March 14, 2025

**Re: Circle K – 10850 Golf Course Rd NE**  
**Erosion and Sediment Control Plan**  
**Engineer's Stamp Date – 3/01/24 (A12E008B1) SWQ-2025-00013**

Based upon the information in your submittal received on 3/13/25, the ESC Plan can't be approved until the following comments are addressed.

EC02

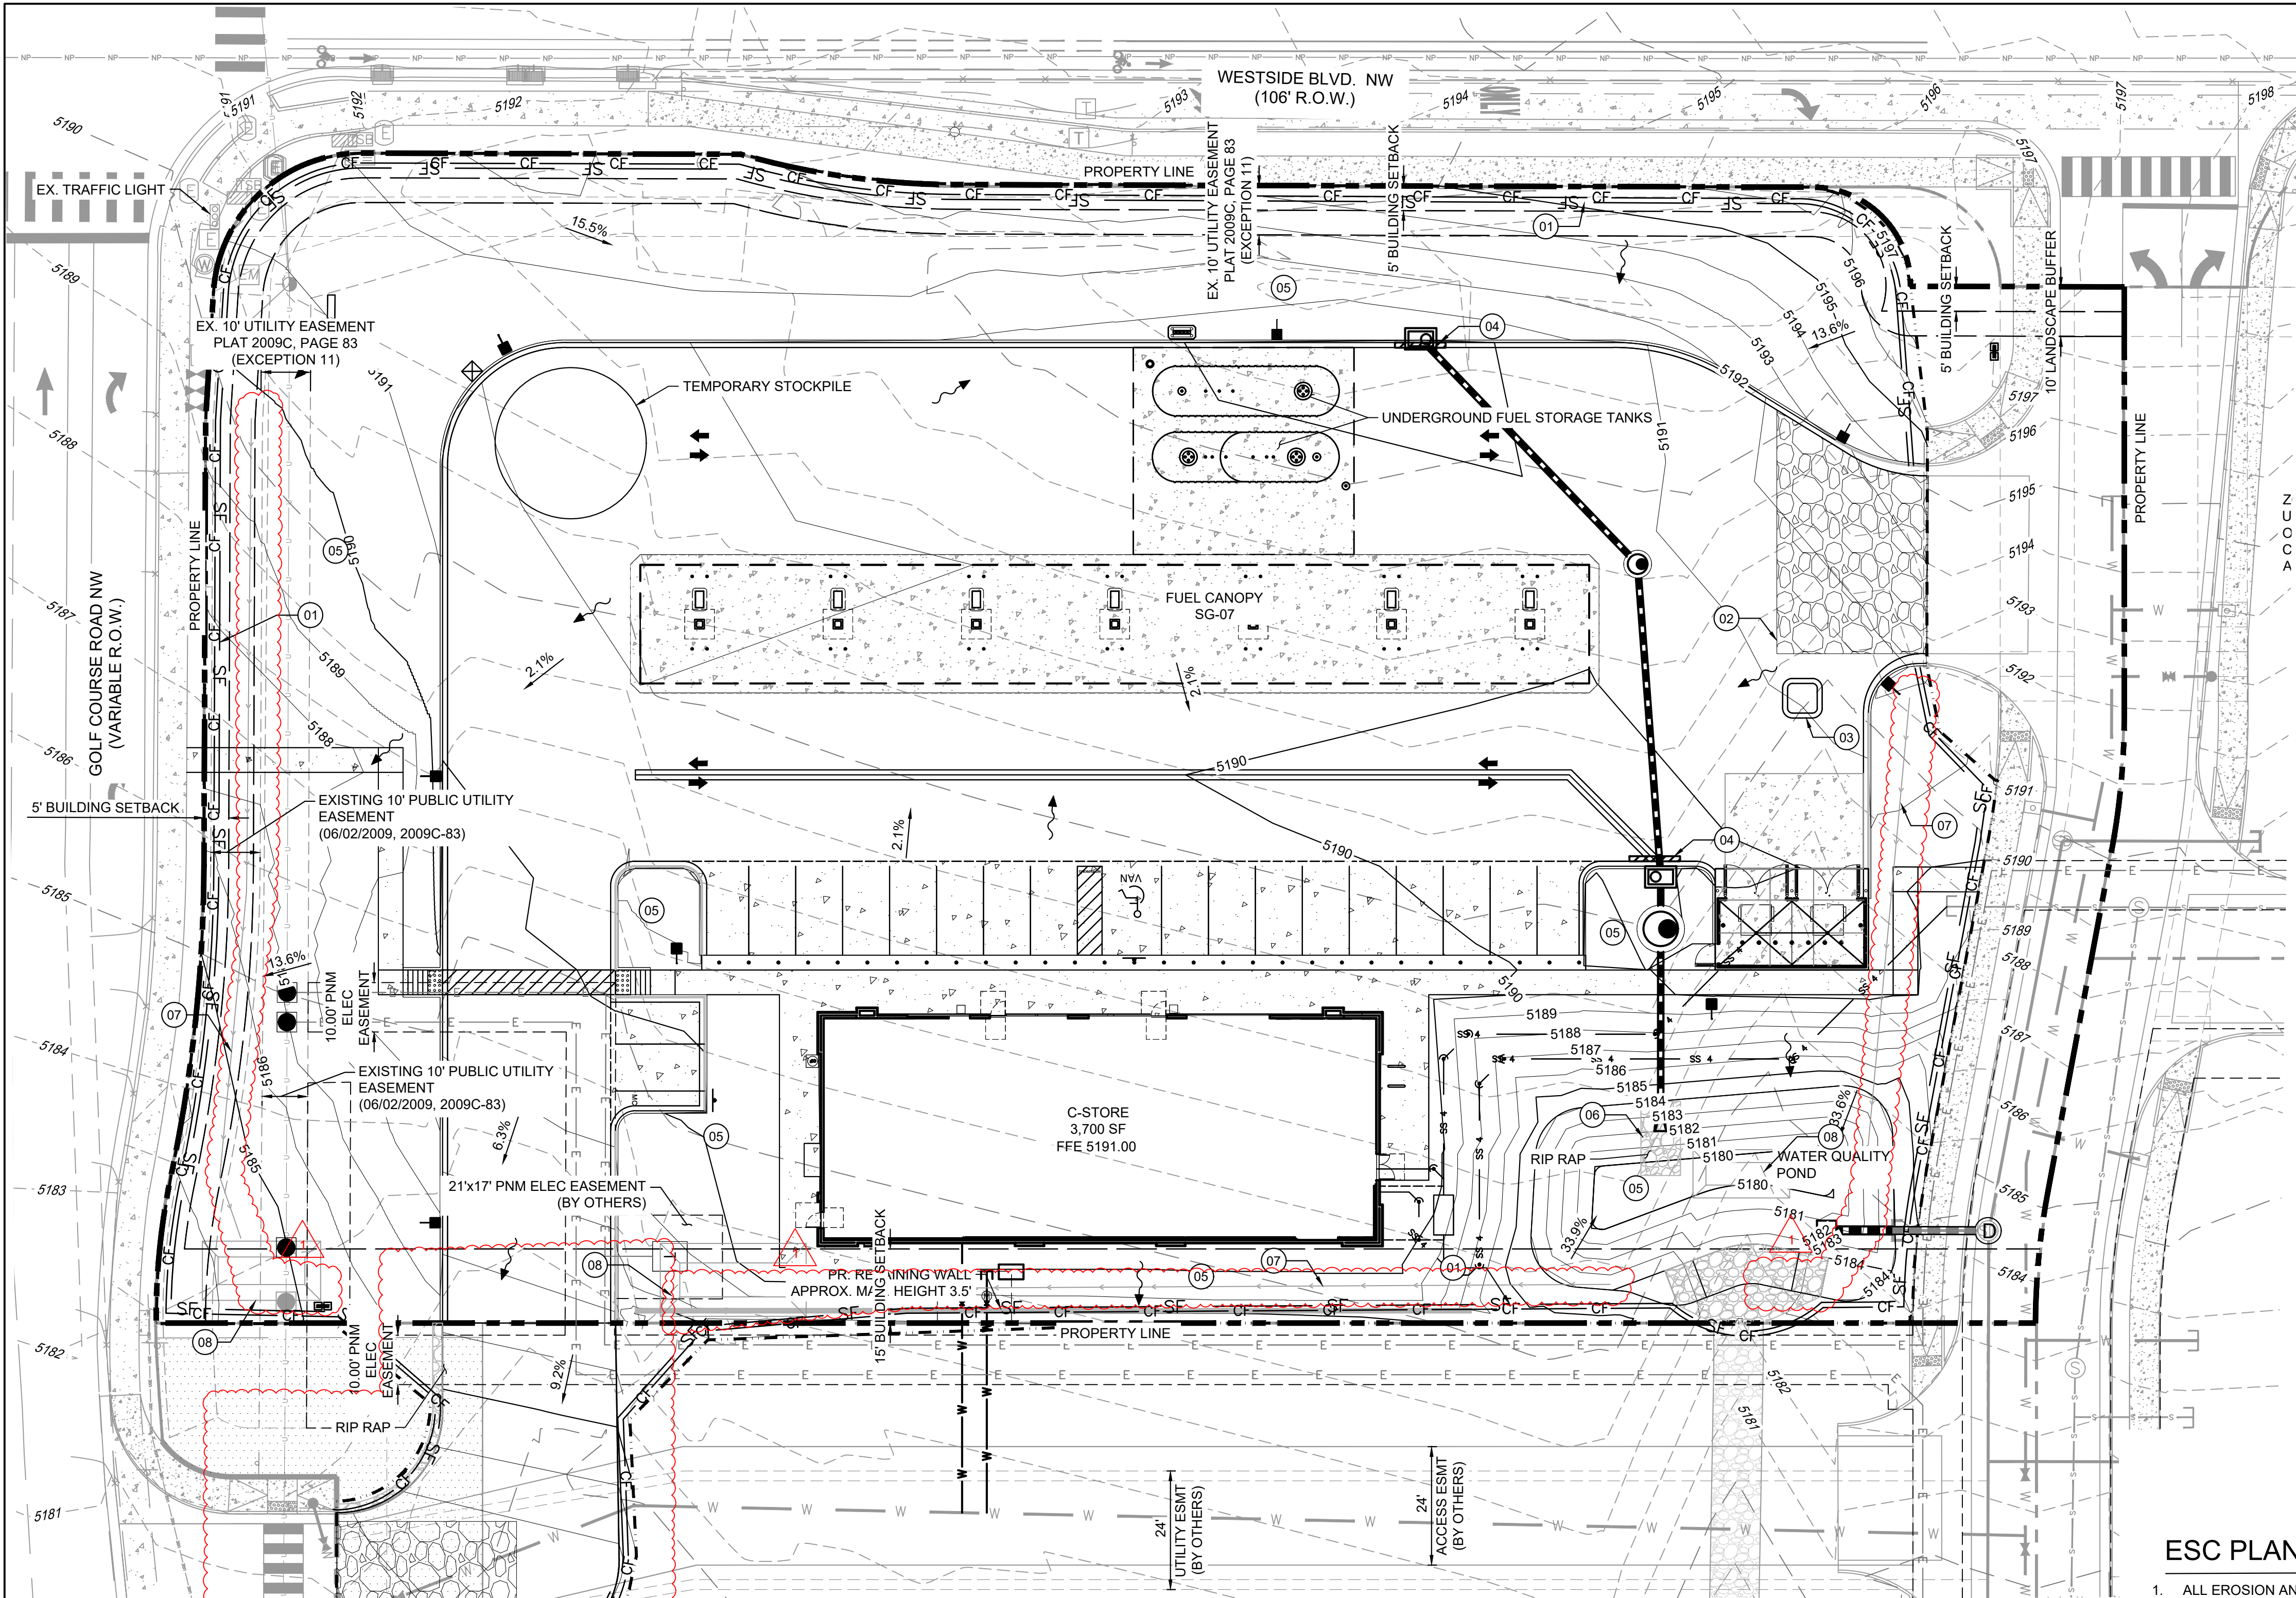
3. Include the sediment traps' design calculations, dimensions, and elevations on the ESC Plan. The revised ESC Plan must be resubmitted in ABQ-PLAN.
4. The ESC Permit Form was submitted in place of the SWQ Information Sheet, so the Information sheet was missing from the application. You must resubmit the Information Sheet in ABQ-PLAN.
